Date: 6/8/01

PROJECT: Bernalillo County Metropolitan Court Parking Structure

PROJECT NO: **20018**

Copies	Date	Description
1	6/7/01	Revised SO19 Sheet

GRADING PLAN

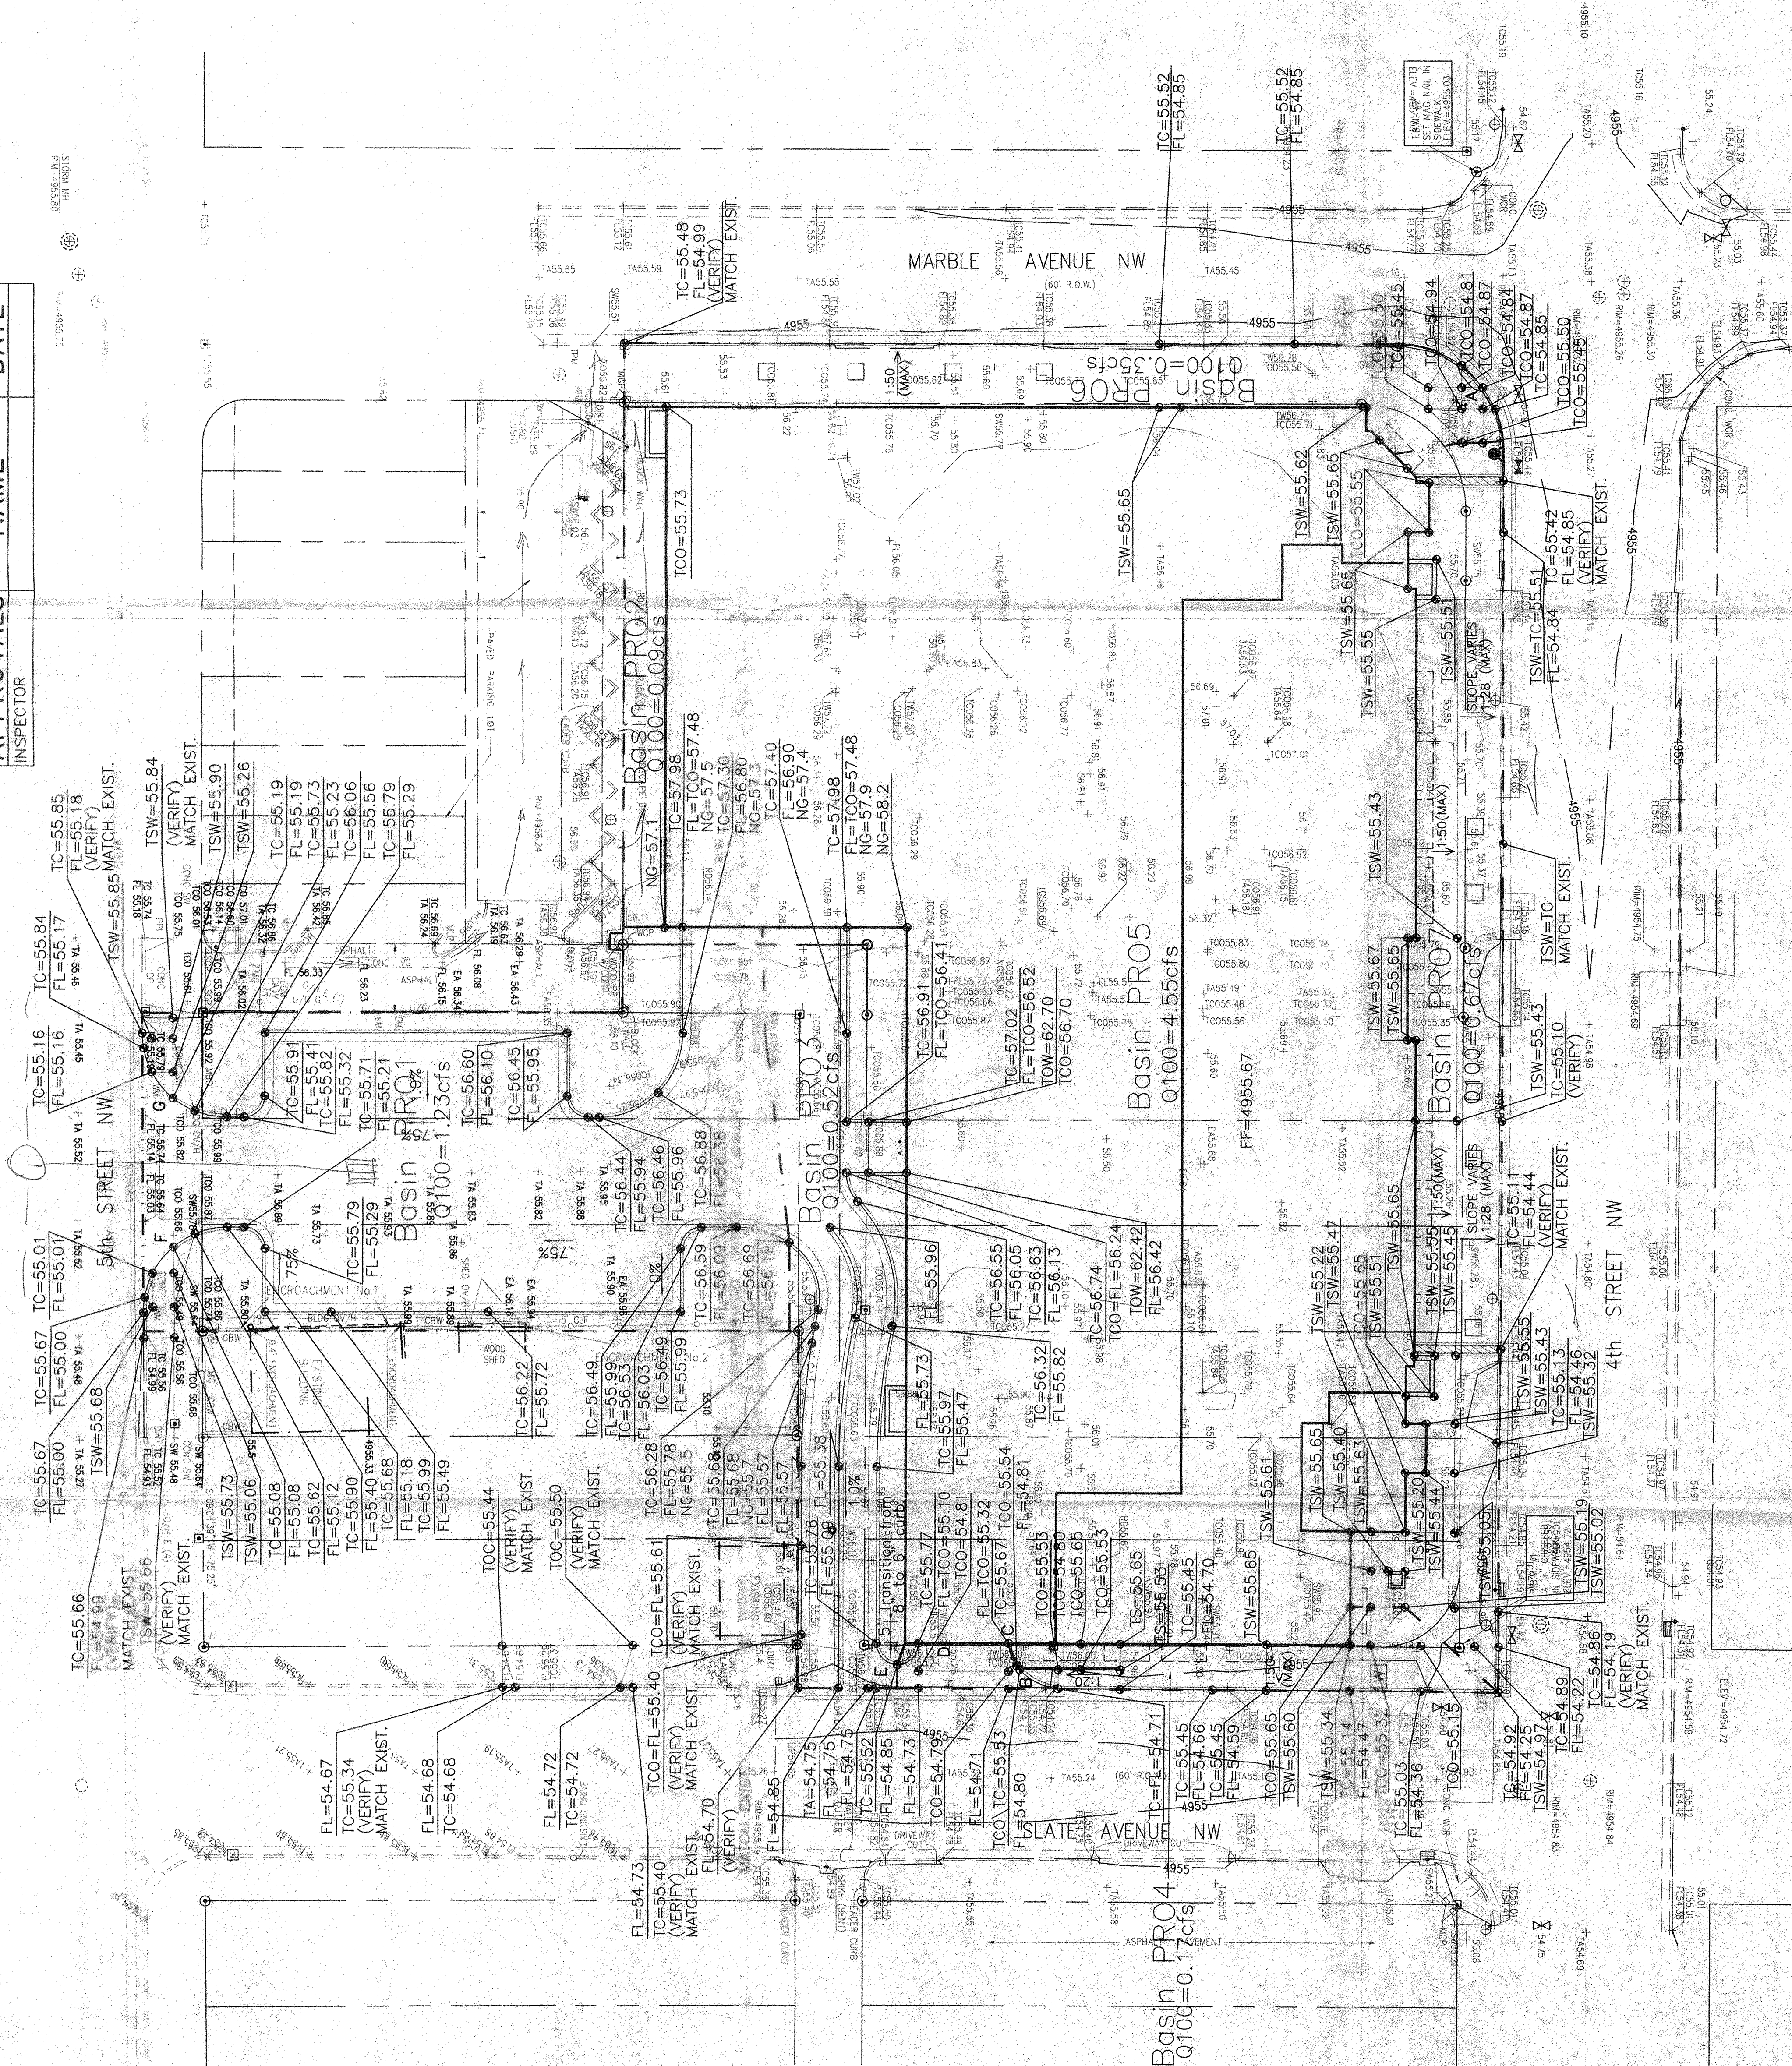
Here is the revised grading sheet showing the 6" water block at the property line as discussed. We have managed to make the site still drain without the addition of a storm drain inlet and connection to the line. There is a swale at the west side of the structure that drains into a new SW culvert. Also, the roof drainage pattern is shown.
